Please ask for: Ms Iqraa Malik
Email: iqraa.malik@terraquest.co.uk
Telephone: 0121 234 1390
Our Ref: BE/149/21/HH
Your Ref:
Date: 11th October 2021

Application for Planning Permission for Works or Extension to a Dwelling

Development: Loft conversion with the installation of 1 x rear dormer
Location: 37 Central Avenue Bersted PO21 5HT

PROPOSED FIRST FLOOR PLAN

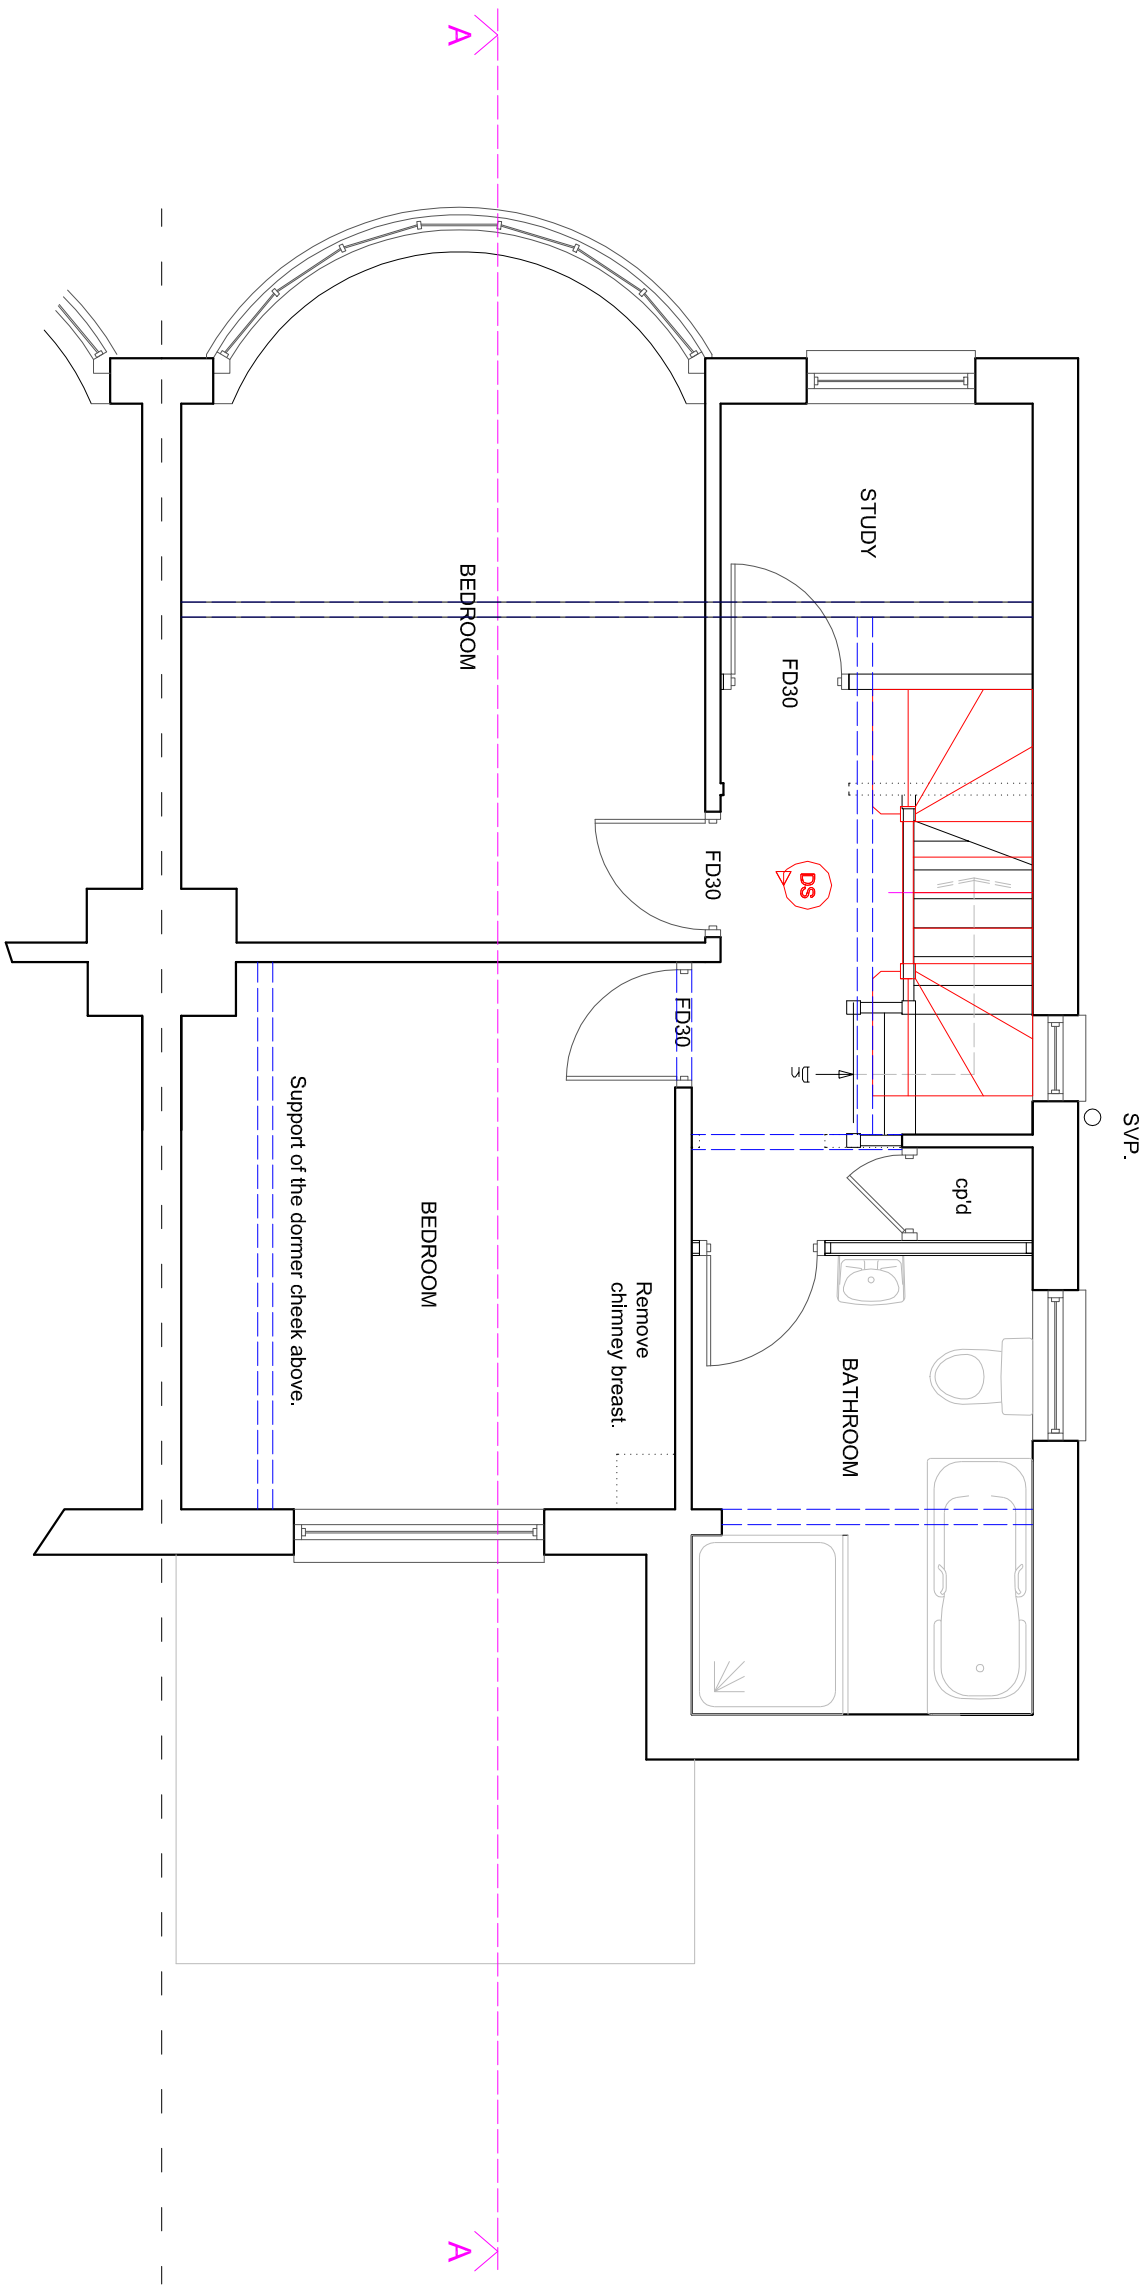
Proposed Plans

The proposed loft plans are labelled as proposed first floor plan. Please amend.

PROPOSED ELEVATIONS

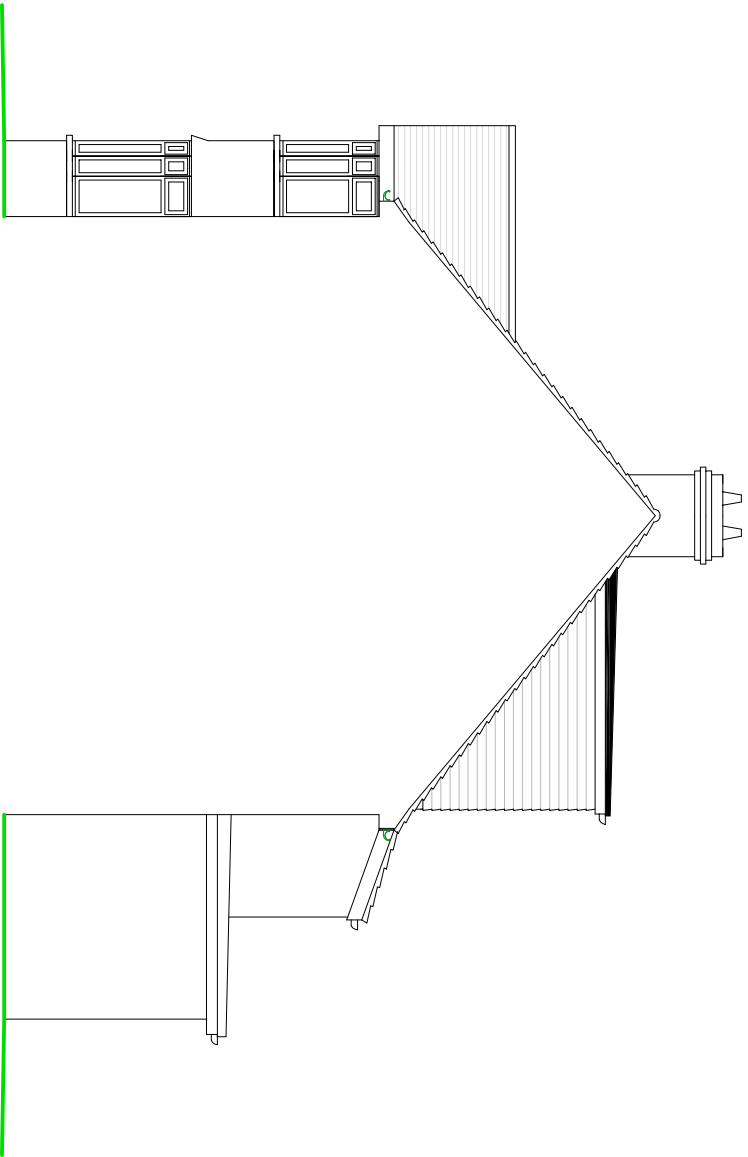
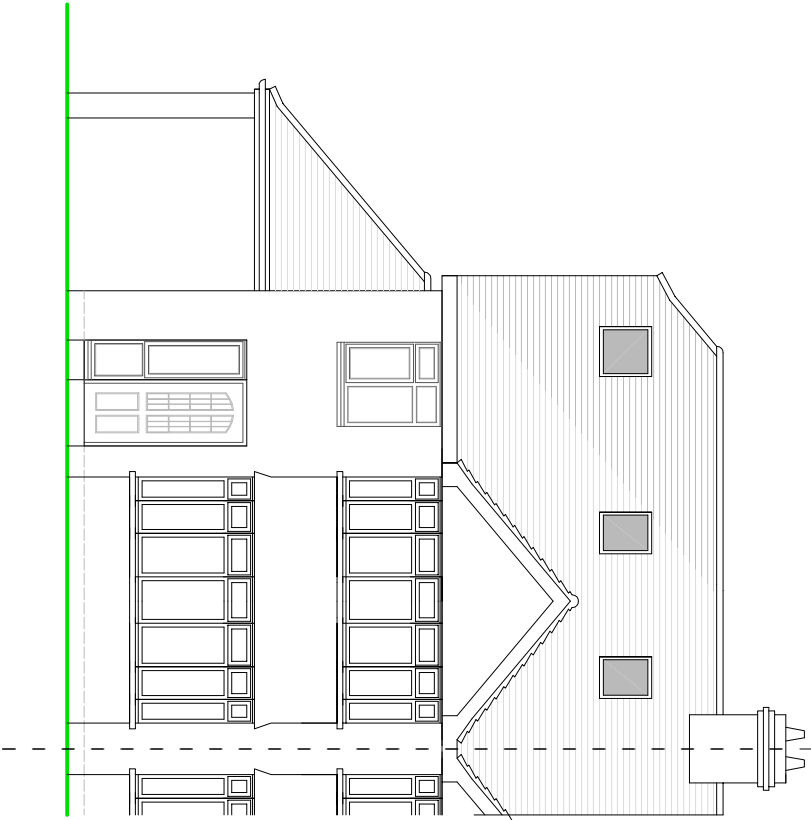
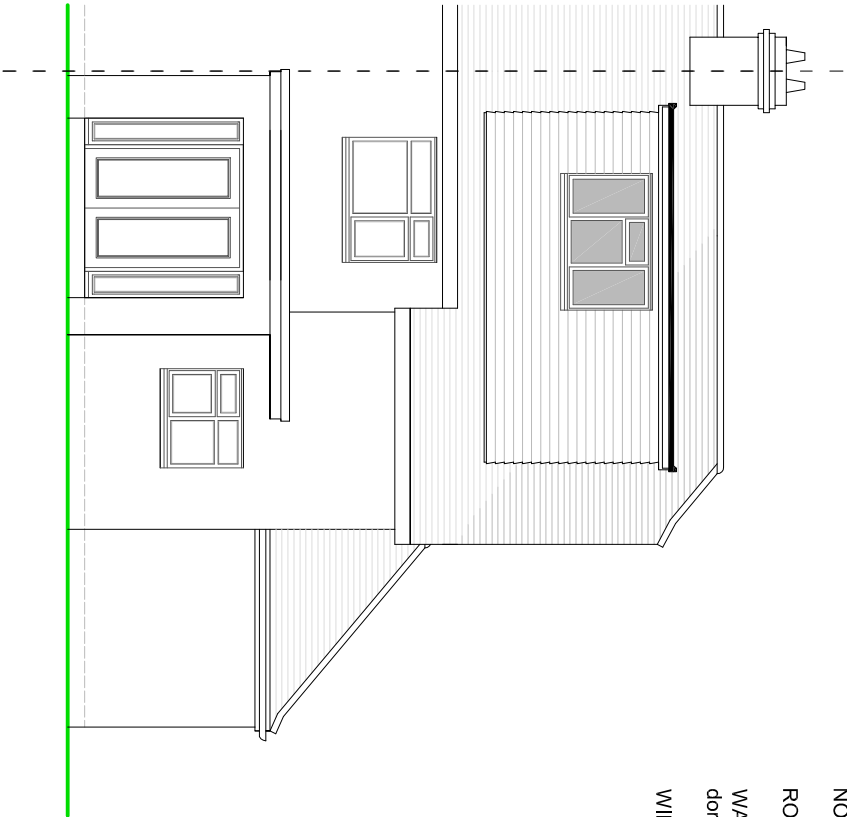
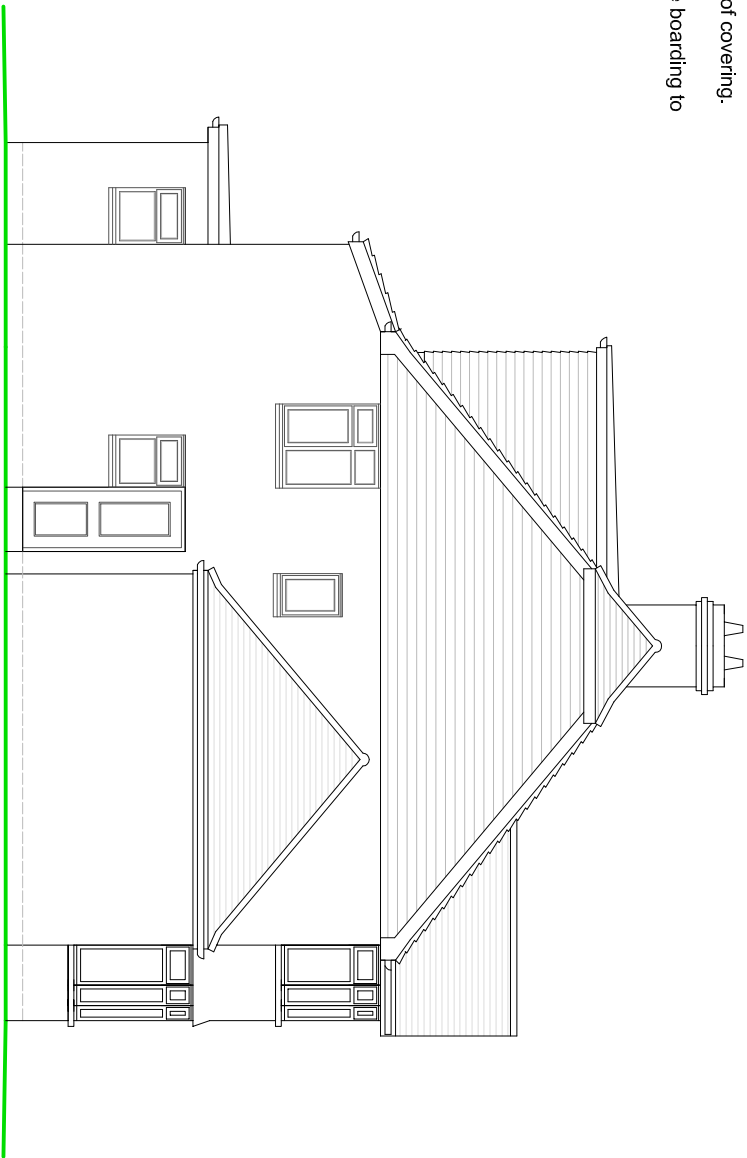
Elevations

Please submit proposed elevations at a scale of 1:50 or 1:100. Further details can be found in the Validation Requirements List.
